SPACE VILLAGE APARTMENTS

SITE DEVELOPMENT PLAN

Space Village Apartments
SITE DEVELOPMENT PLAN
Colorado Springs, CO

COVER SHEET
DP1

SPACE VILLAGE APARTMENTS
SITE DEVELOPMENT PLAN

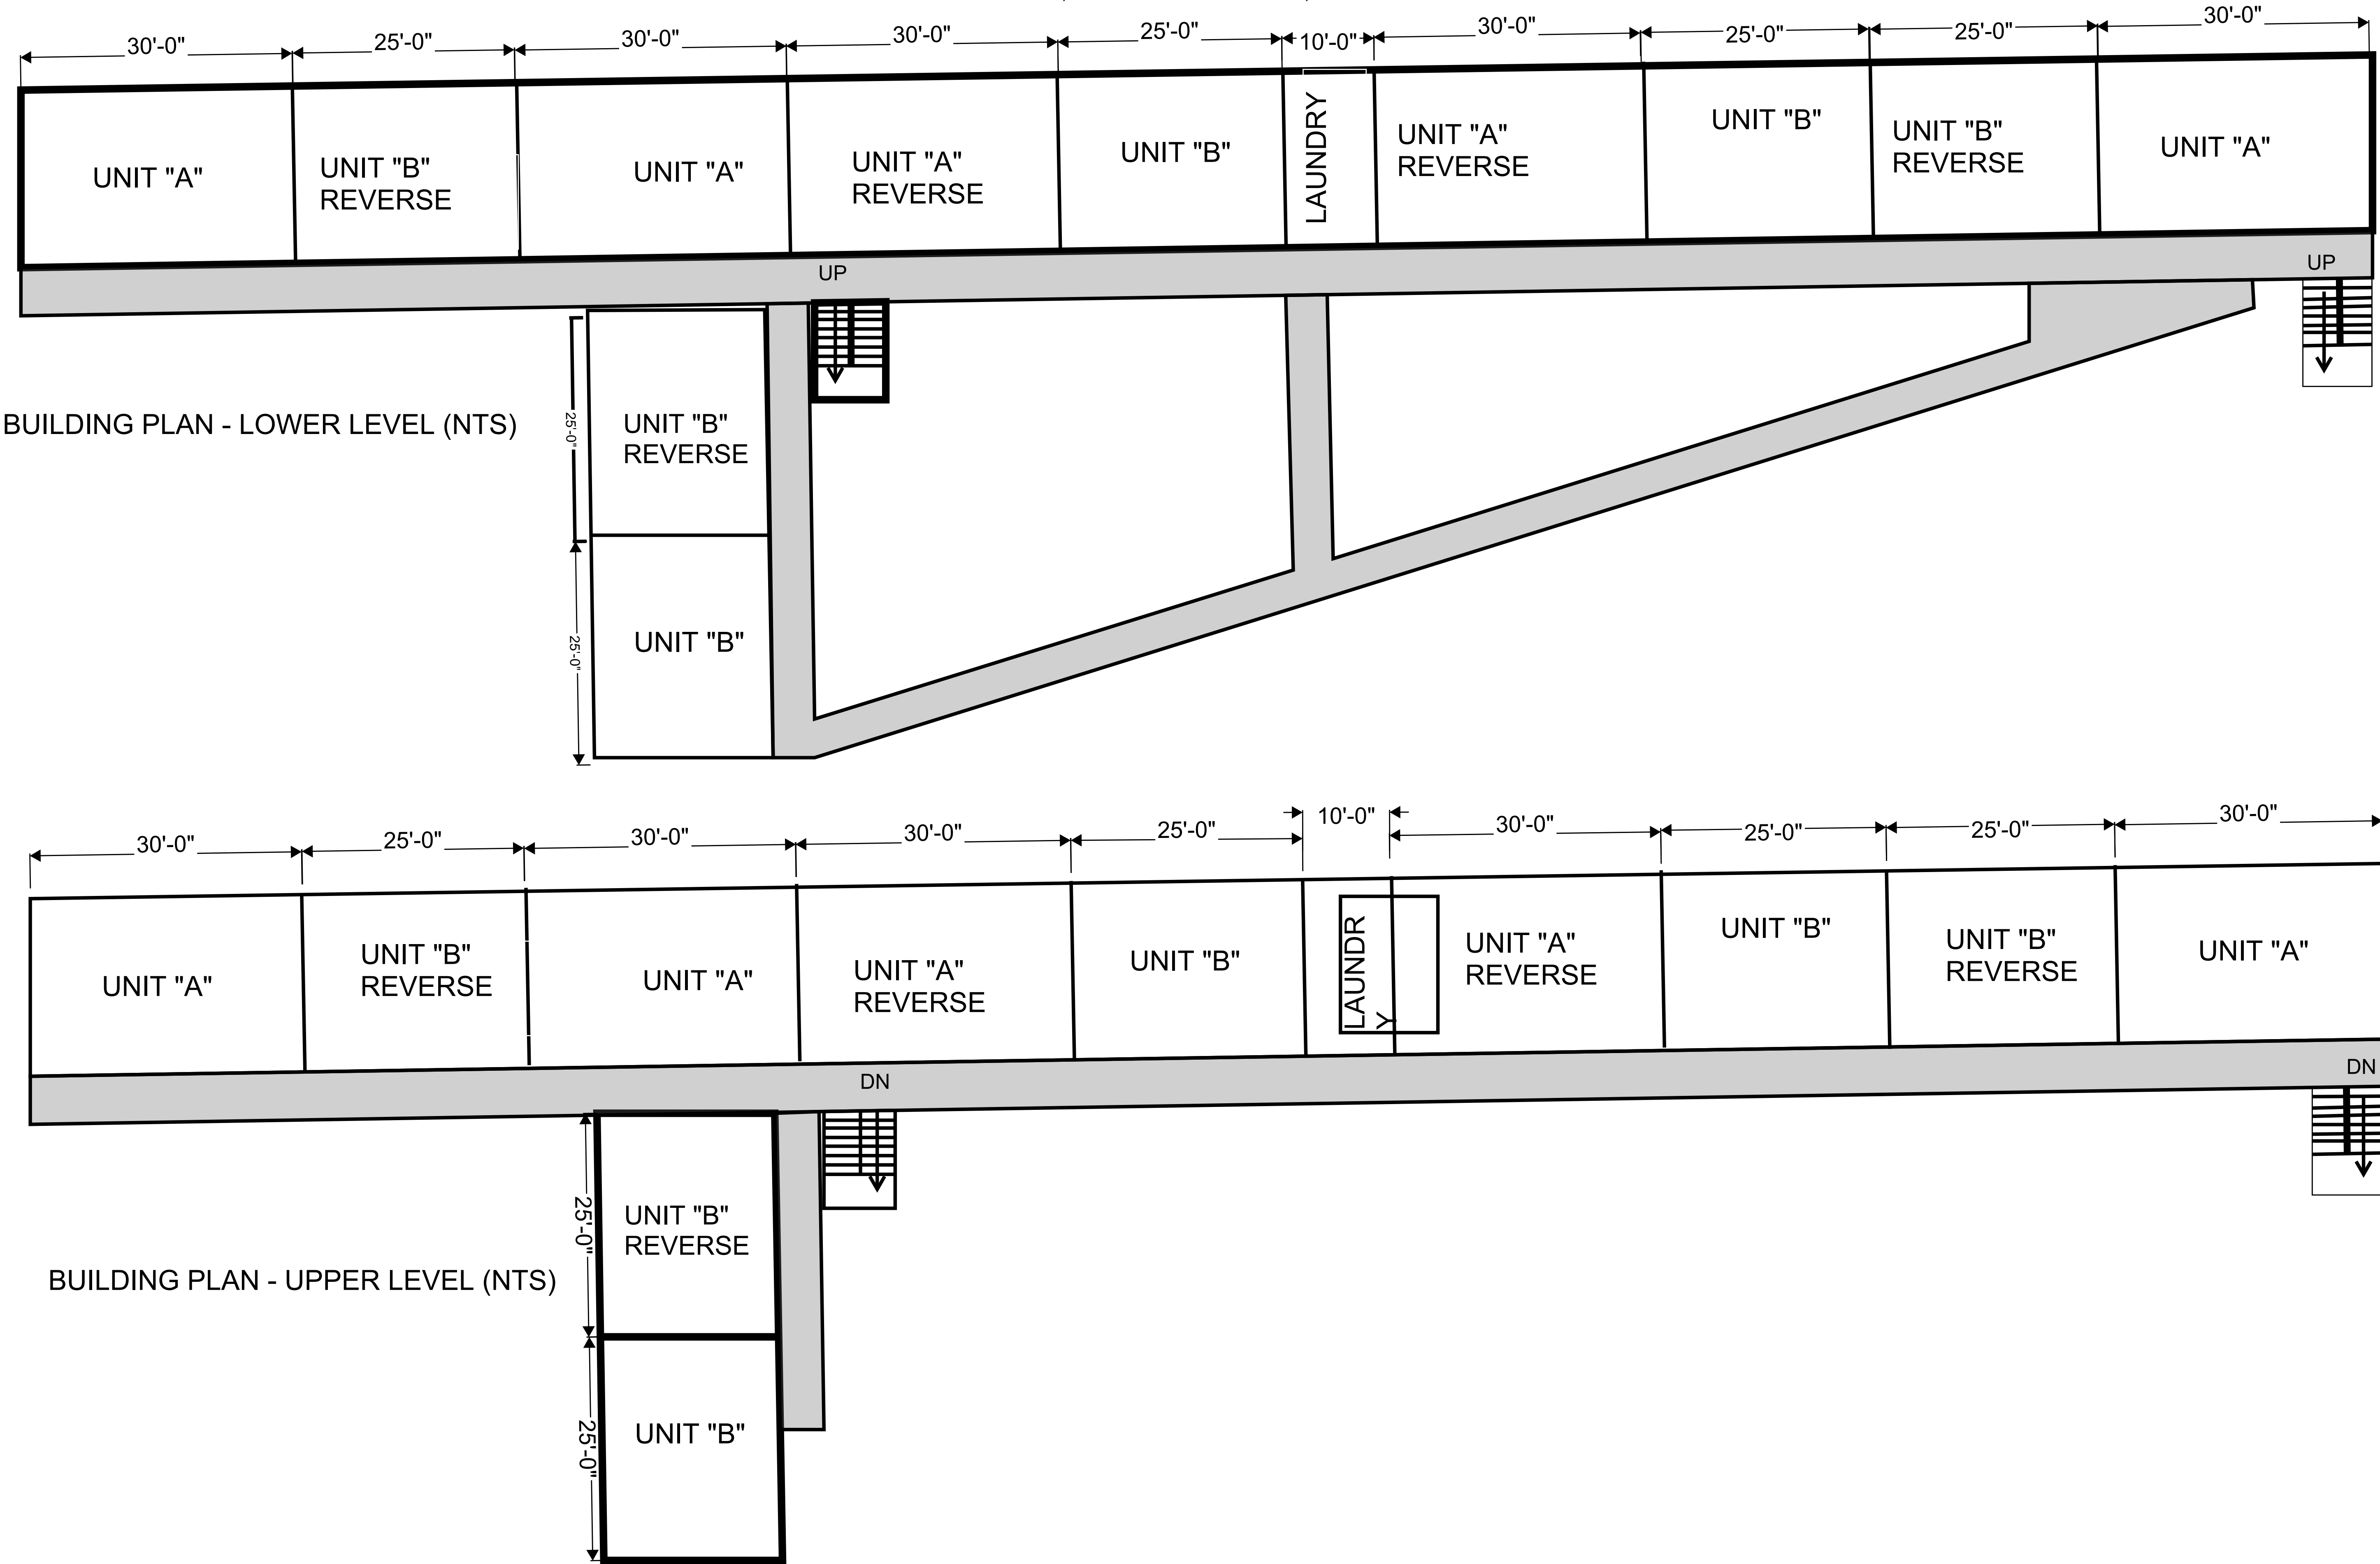
Please add the following to the site plan:
Owner and applicant contact telephone number and email
Legal description
Existing/proposed land use
Open space, landscaping, and impermeable surface percentage
Density and total number of dwelling units (residential)
The footprint of all existing and proposed buildings
Traffic circulation on site including all points of ingress/egress into the property
Location of all ADA spaces, ramps and signs, including ADA pathways
Please show dimension of parking spaces so we can verify it meets the code requirement
Location of all garbage receptacles with a graphical depiction of the screening mechanism
Location of all existing and proposed utility lines and associated infrastructure
